Harnett County Department of Public Health Site Sketch

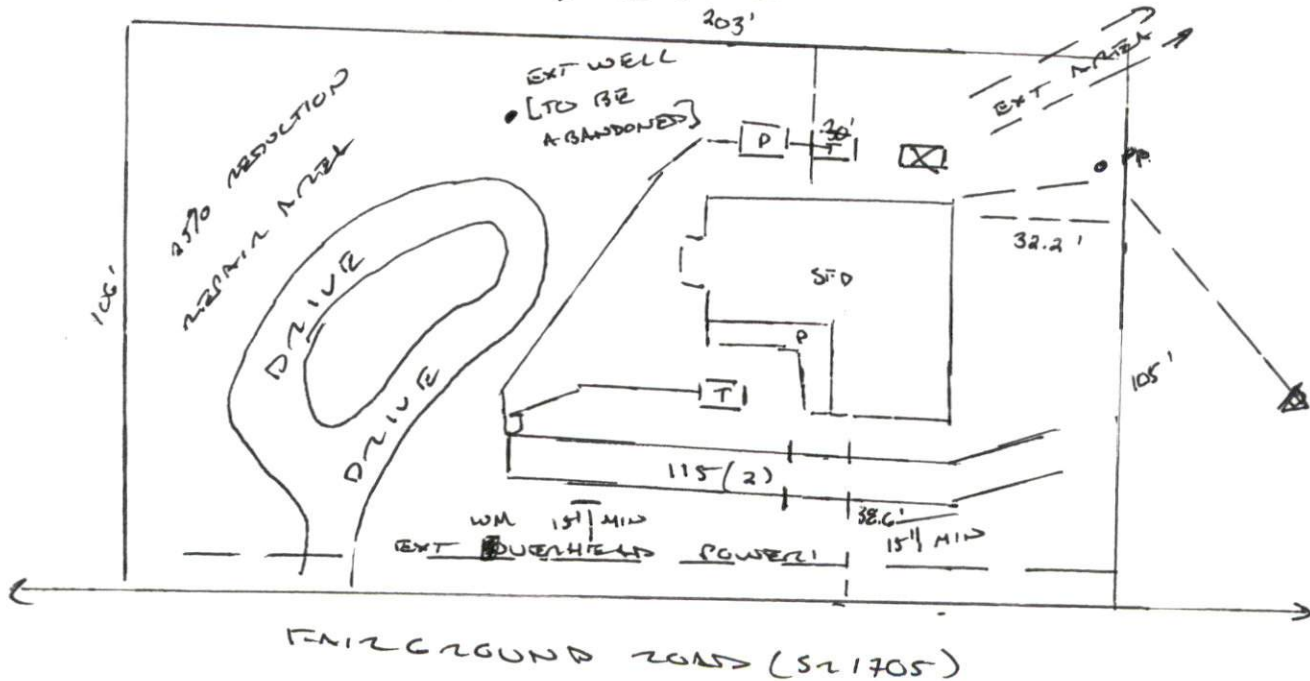
- * MAKE P.L / SURVEY MAP
- * ABANDON WELL
- * PROVIDE SOIL REPORT
- * INSTALL DEEP TO SHALLOW W/ STEPDOWN
- * FLANGED 15 FT OF POWER [28 IN - 12 IN DIA]
- * WATER LINE SHALL BE RELOCATED
